## **Submission Objecting to State Significant Development Application SSD-119545240**

**40-76 William Street, Leichhardt**

2 West Elevation  
SCALE 1 : 200

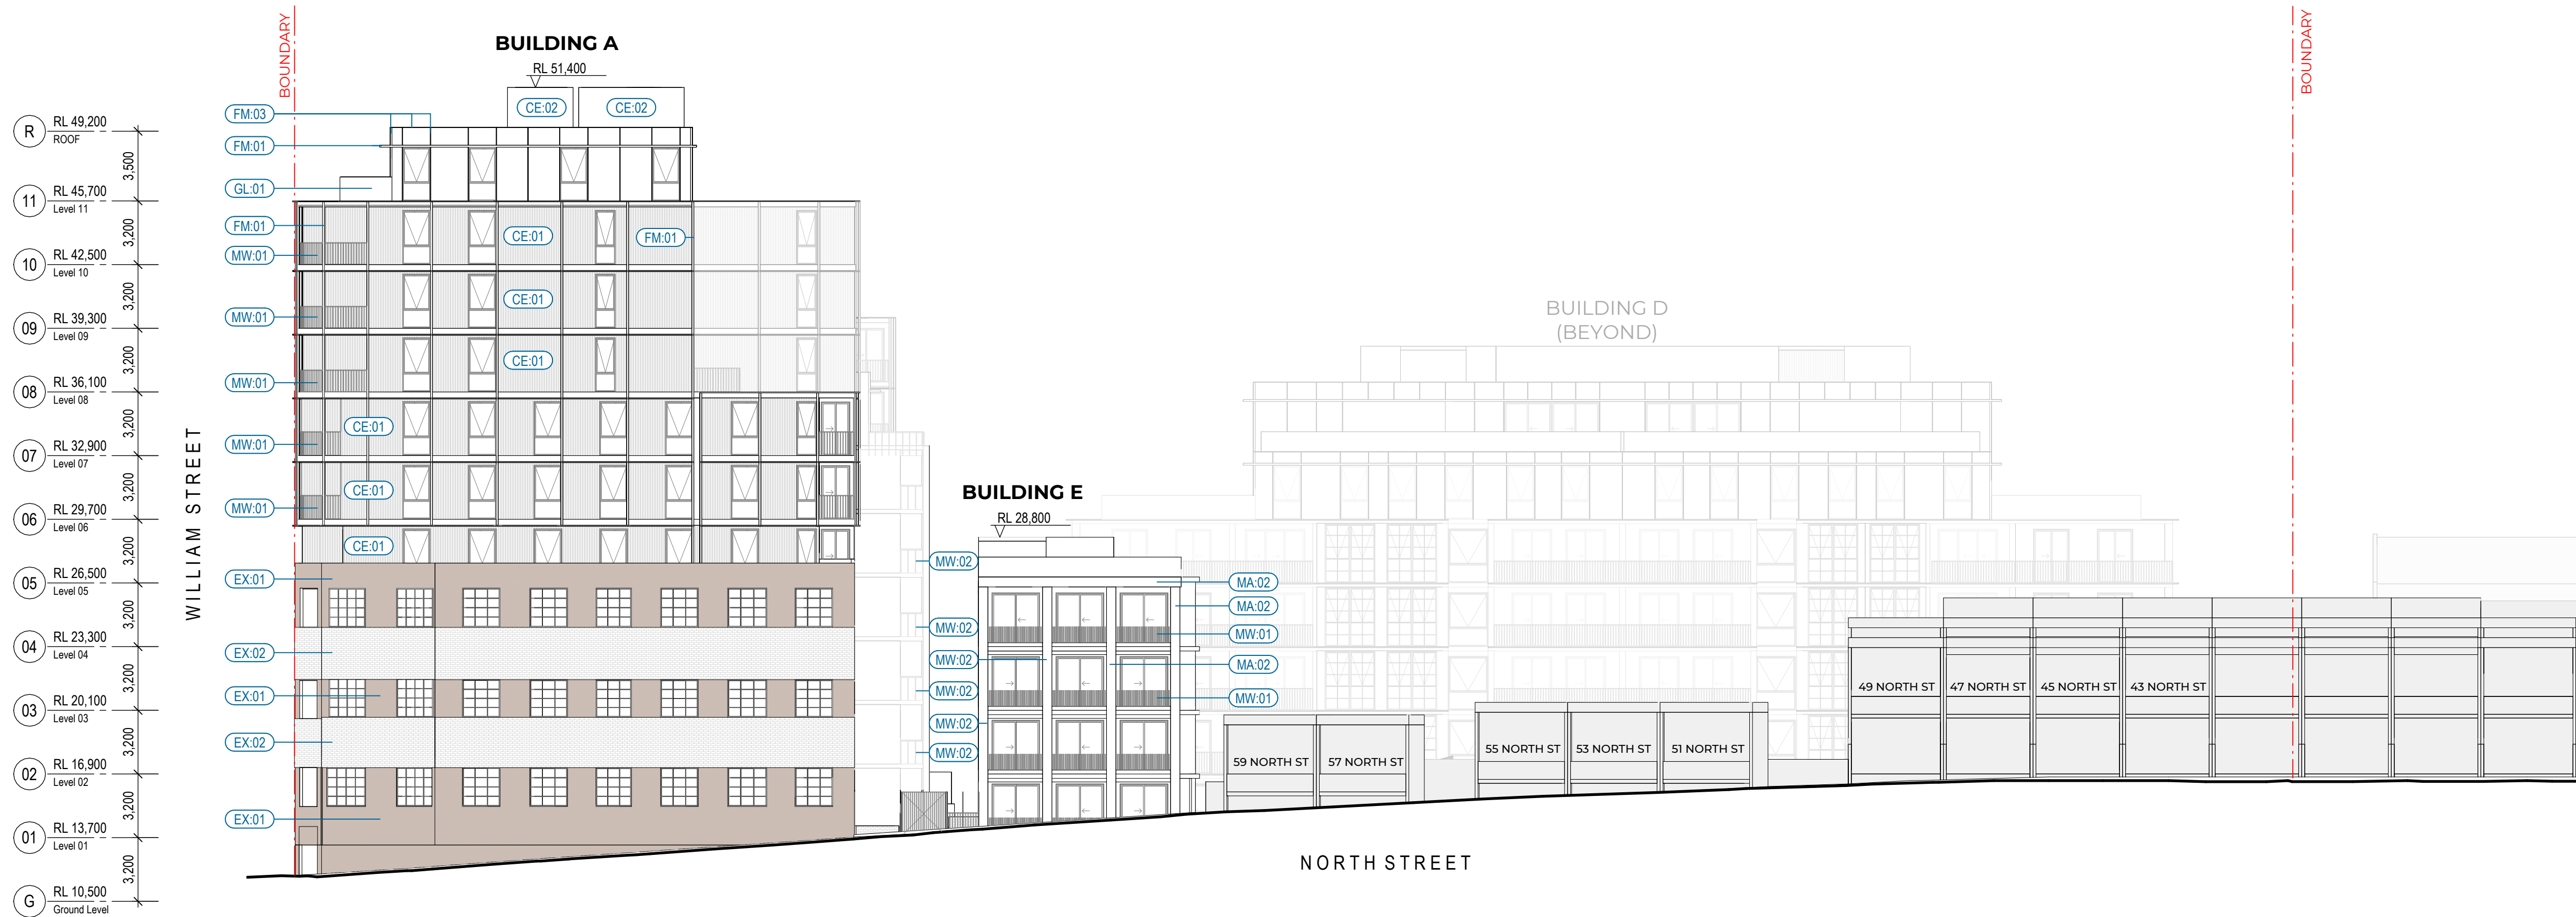
According to the submitted plans, the proposed development includes a building of approximately eleven storeys, considerably exceeding the prevailing height of surrounding development. The difference in scale would have a substantial impact on the character of the street and would be visually inconsistent with the existing low-rise heritage environment.

If redevelopment of the site is considered appropriate, the built form should respond more closely to its context. In particular, the height should be substantially reduced and should not exceed the scale of the existing building on the site, which I understand to be approximately four storeys.

I also note that a small terrace has nowhere to hide from buildings that tall. Buildings of 11 storeys loom over our small terraces, meaning people can see directly into our courtyards and living rooms. I have attached a photo of what the terraces look like in this area. You can't possibly think having 11 storeys looming over these terraces is appropriate.

- Fixed privacy screening and hoods on every window and opening that faces Francis Street and the terraces, so people are not looked down into.
- No balconies on the faces of the building that look towards Francis Street and the terraces, since balconies are where the overlooking happens. All other balconies to be deeper with planter boxes.

- A substantial reduction in the overall height and bulk of the development.
- A built form that better reflects the scale and heritage character of the surrounding streetscape.
